Planning Application Ref: AW/59/17/TC

Location: 92 The Fairway, Aldwick Bay

Description of works: Fell 2 No Monterey Cypress trees.

SHEET 1

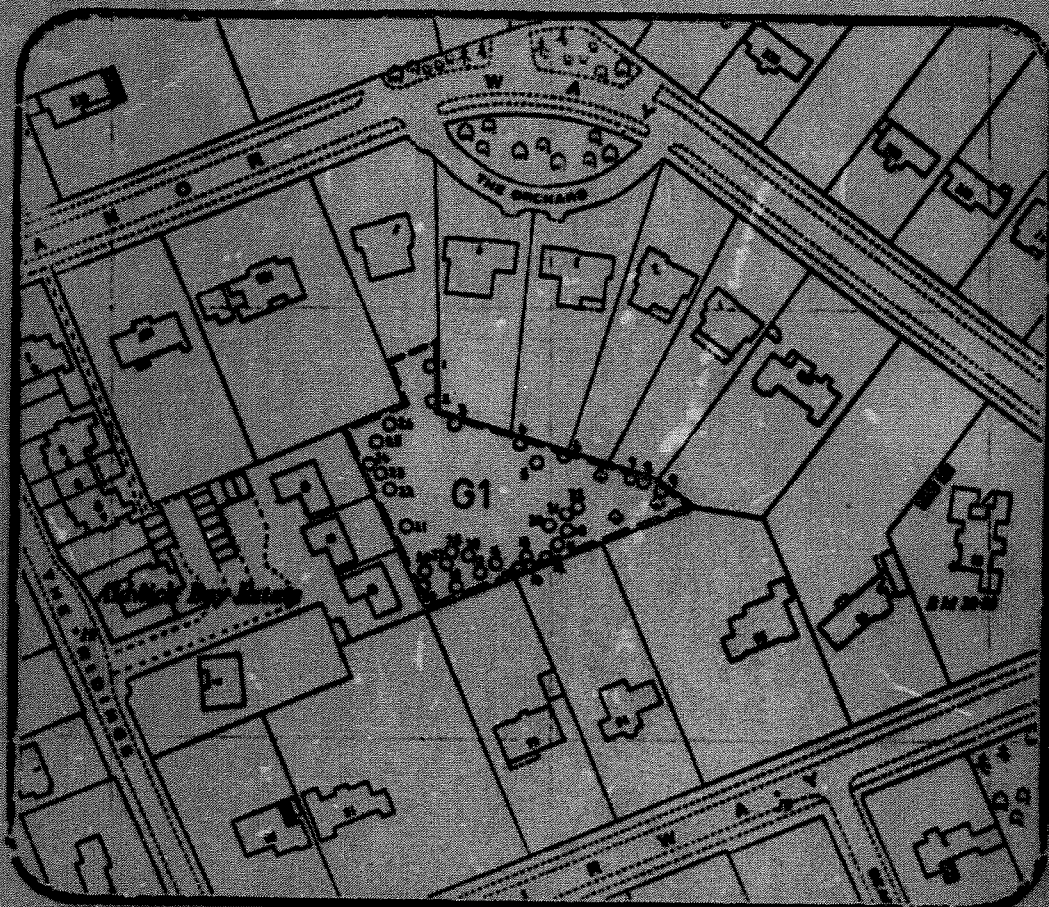
- A pair of ragged looking conifers located in the neighbours garden.
- These trees are full of deadwood and dieback and are generally of poor shape and form.
- Half of their crowns overhang 12 Hunters Close.

- None of these trees are worthy of a TPO.
- However, the applicants do not own the trees – therefore they will need to get the owners permission before undertaking any works to them.

- I raise **No Objection** to the works that have been applied for but advise that the applicants talk to their neighbours about the situation before proceeding with works.
